White Rock *Wind Farm*

Alternative Powerline Modification

Submissions Report

July 2013

Figure 3.13 – Vegetation Mapping Point 12 to Point 13

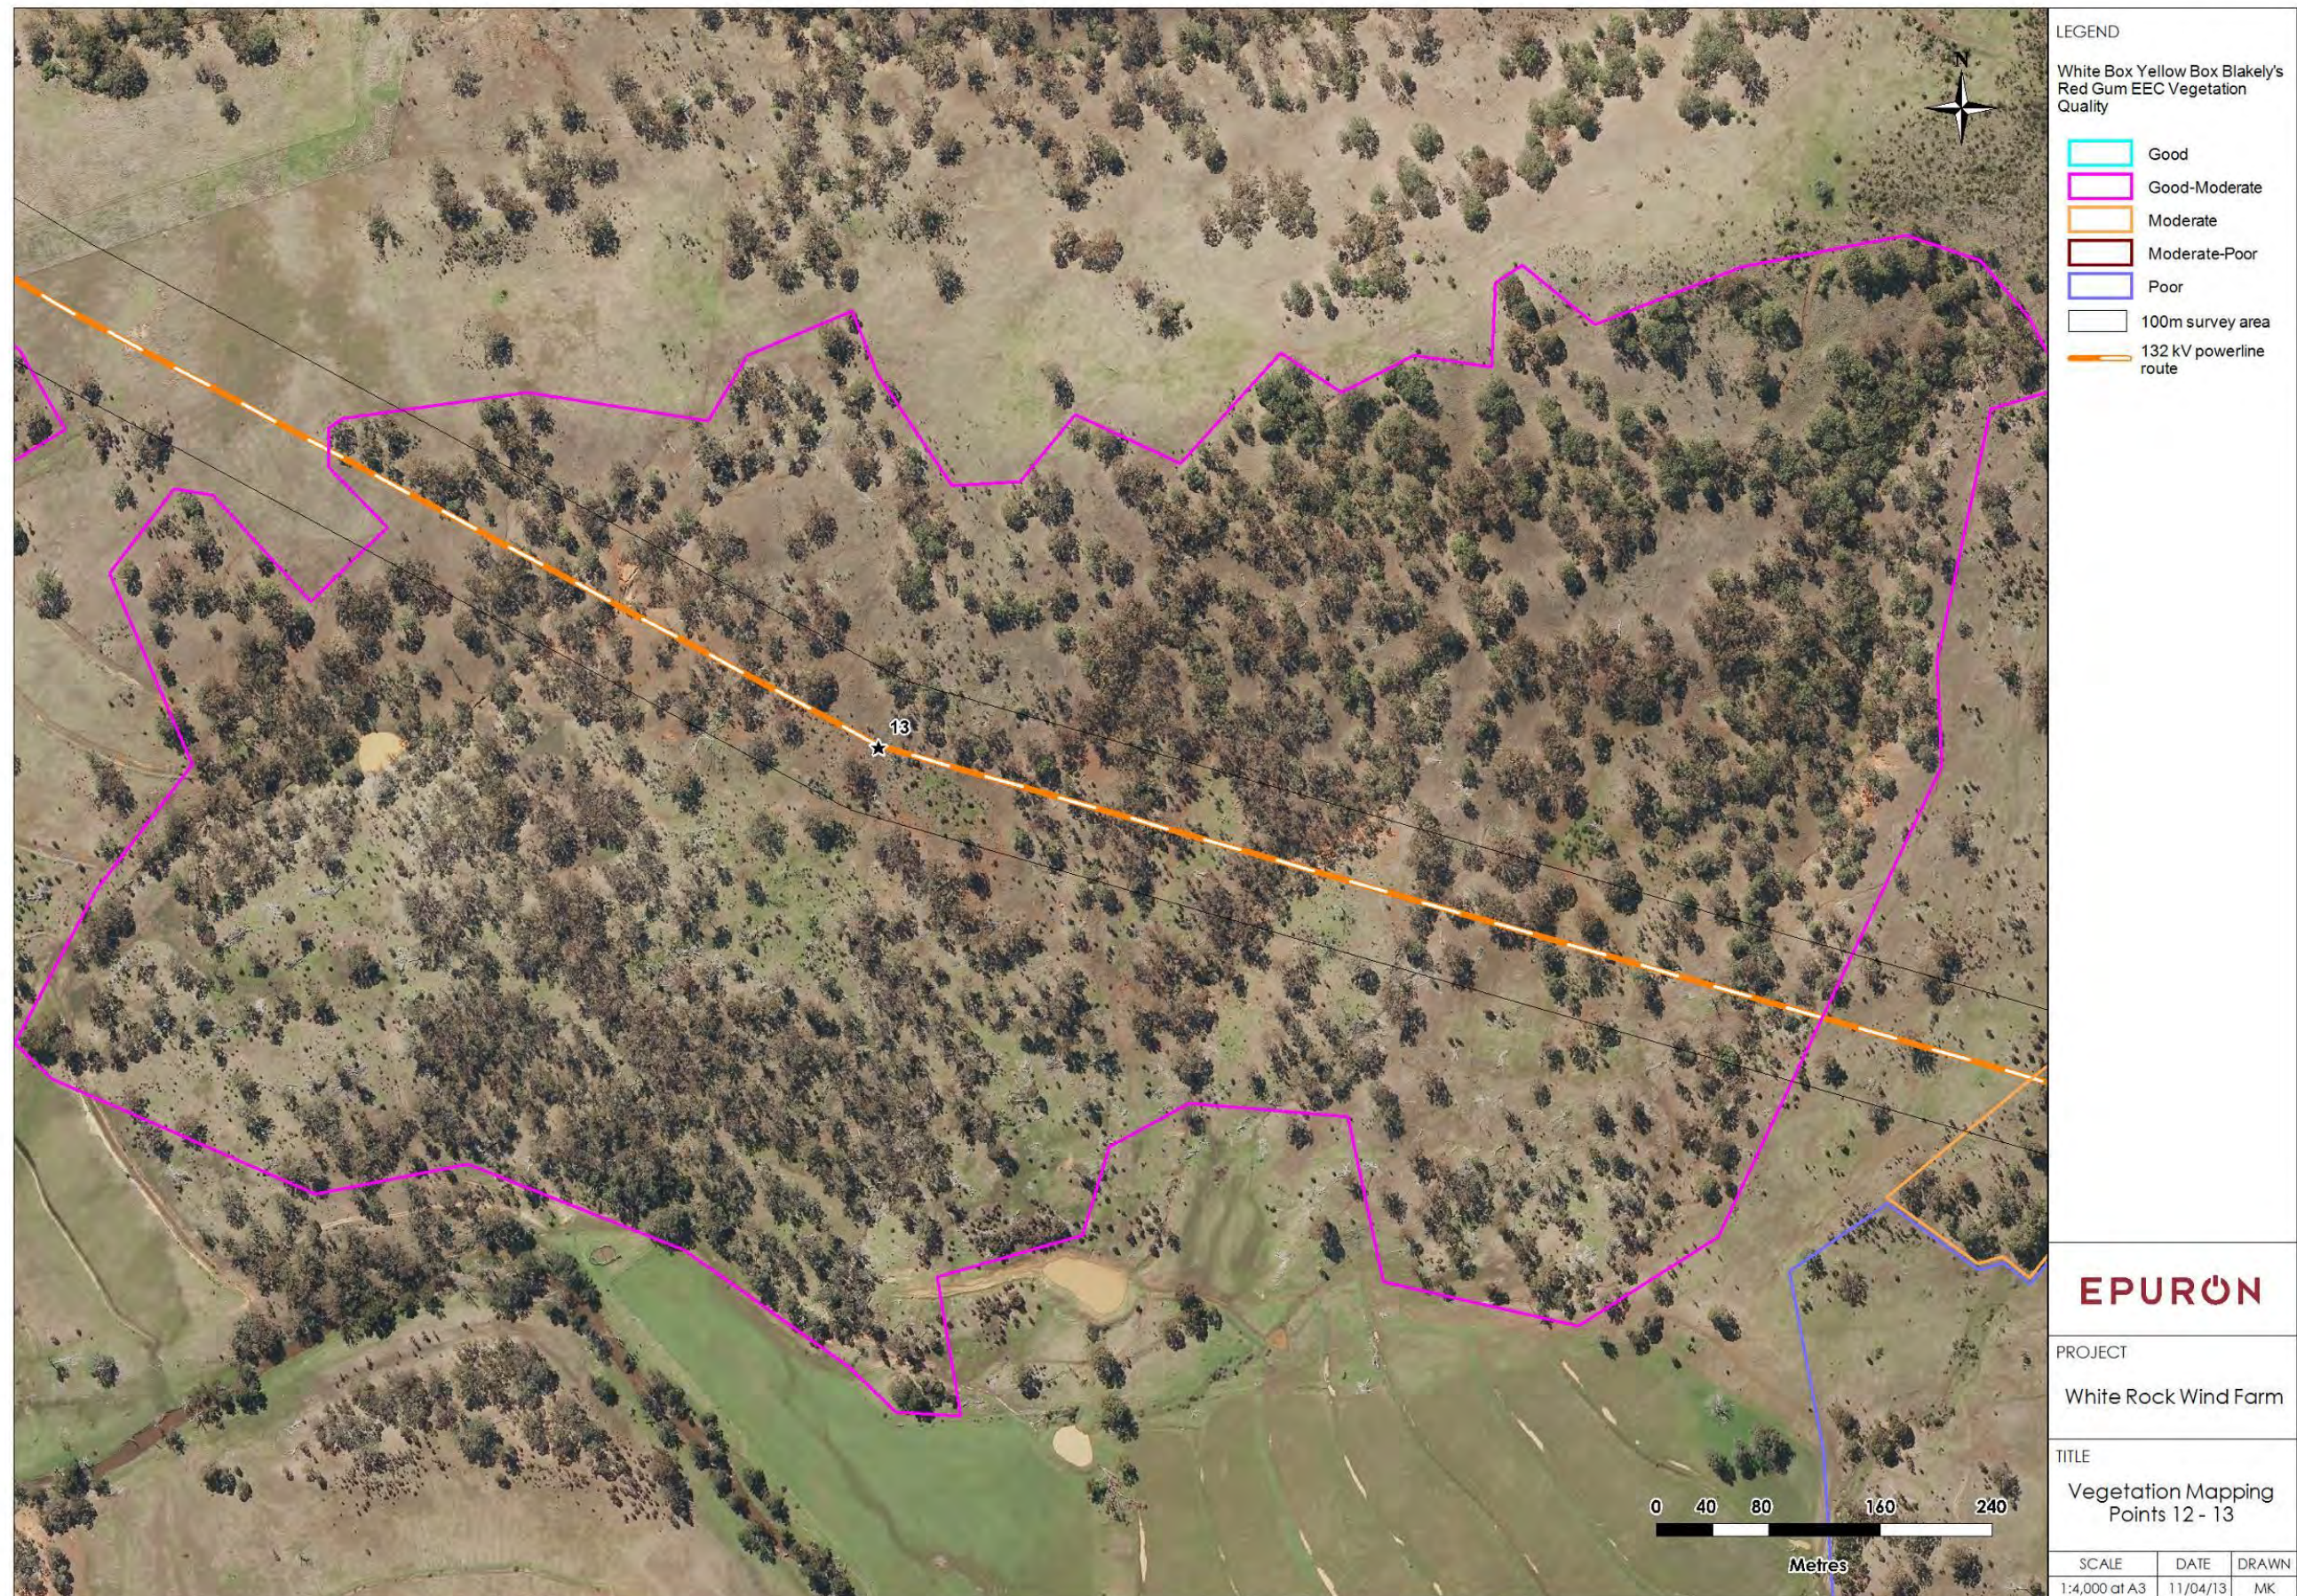
Issue 5: Native vegetation has not been adequately mapped and therefore quantum of the impact has not been correctly determined.

Recommendation: Vegetation maps must clearly show each vegetation type, by condition, within the impact area. This should include all native vegetation not just EECs. Ideally, the BioBanking Assessment Methodology should be used to guide these assessments.

The detailed vegetation maps (Figure 3.6 to Figure 3.15) on the following pages have been updated to clearly show each native vegetation type and its condition. The impact area as a result of the permanent clearance of native vegetation required to provide the safety clearance (7.5m) from the powerline conductors has also been highlighted. Plot data (using the standard DECCW Vegetation Field Survey Forms) for each of the quadrants and transects was included in Appendix 3 of the Biodiversity Assessment included in Supporting Document (January 2013). Updated impact area calculations have been carried out to confirm the impact on each vegetation type by condition.
